Our Ref: K/22/09/

Construction of third floor extension with flat roof, first floor balcony access to sun deck, garage extension, additional driveway parking & boundary wall erected to front of property

Chelsfield 53 Coastal Road East Preston

Kingston Parish Council has the following objections and comments on the development proposed in planning application K/22/09: ☐

Ground Floor

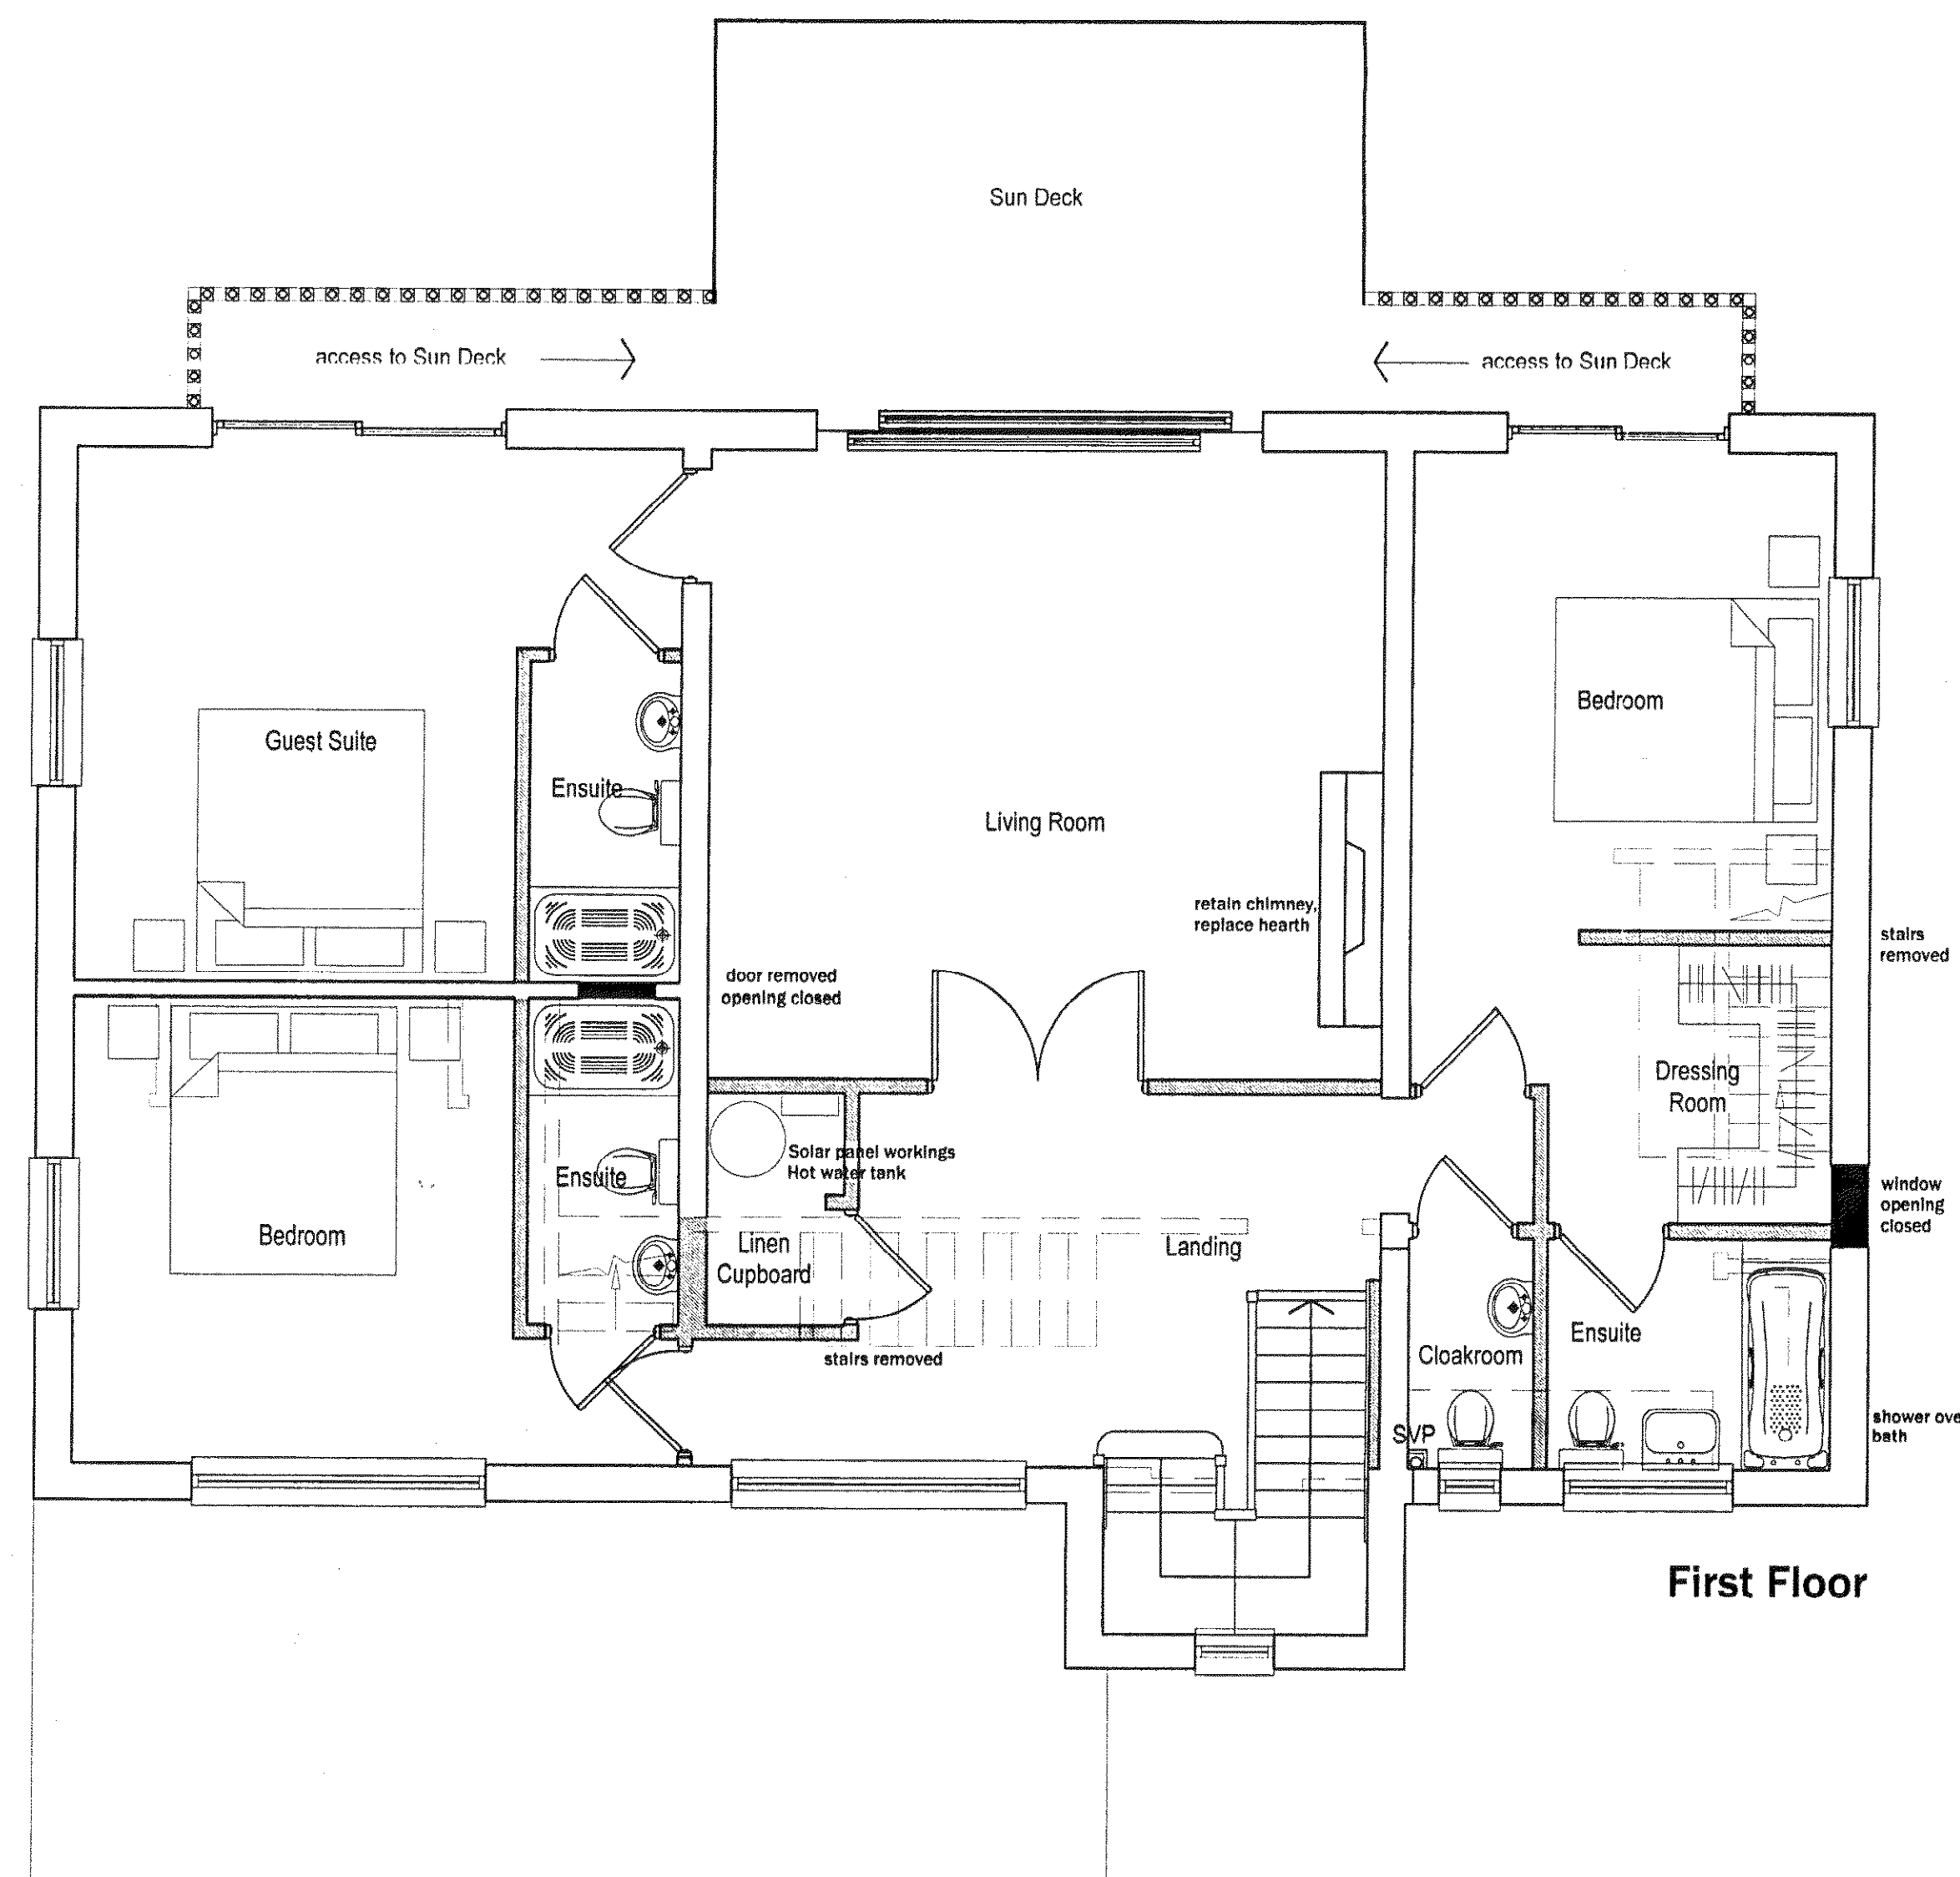
5. The proposal for a second floor balcony should be refused because it is intrusive on the privacy of neighbouring properties. ☐

6. The proposal for the extended first floor balcony should not be allowed unless opaque 1.8m high side screens are provided to the east and west of the balcony because it is intrusive on the privacy of neighbouring properties.

Drawing
**Existing Elevations
Proposed Elevations**

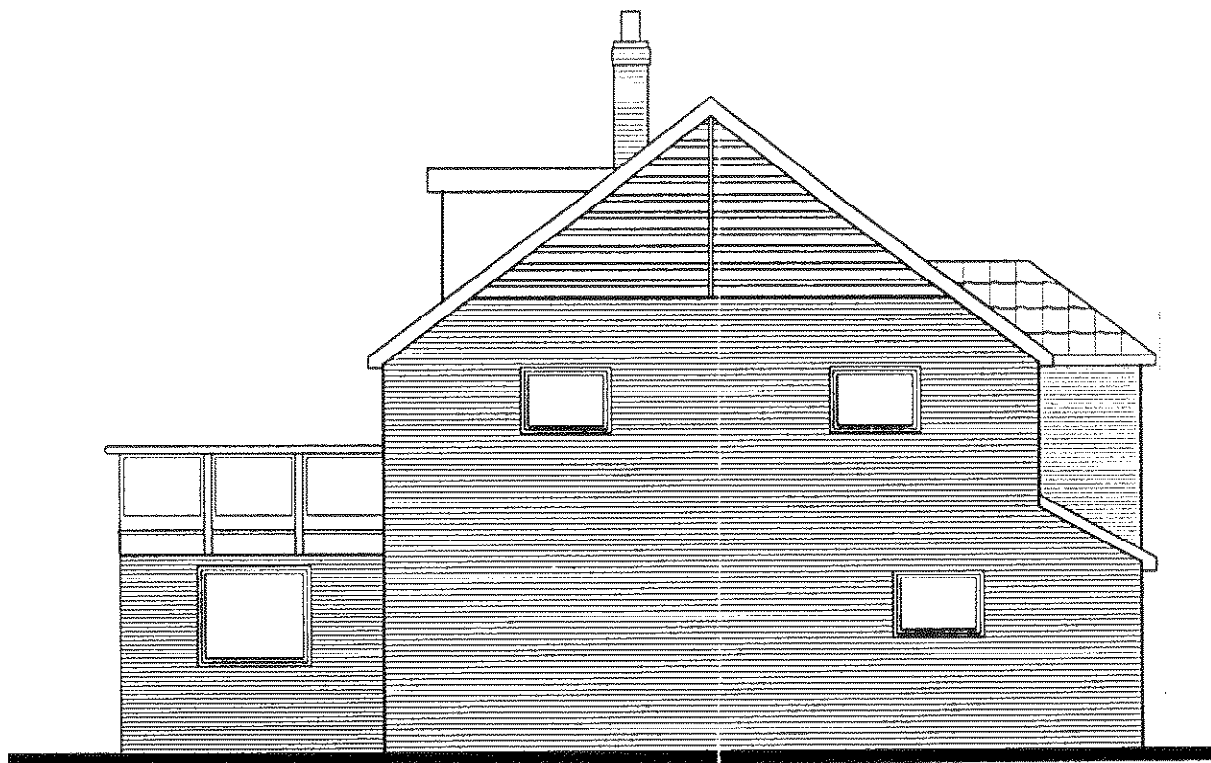
1. It is out of scale and out of character to the existing property. ☐

2. It is an intrusion into the visual amenity of the neighbourhood and will be detrimental to the street scene. ☐
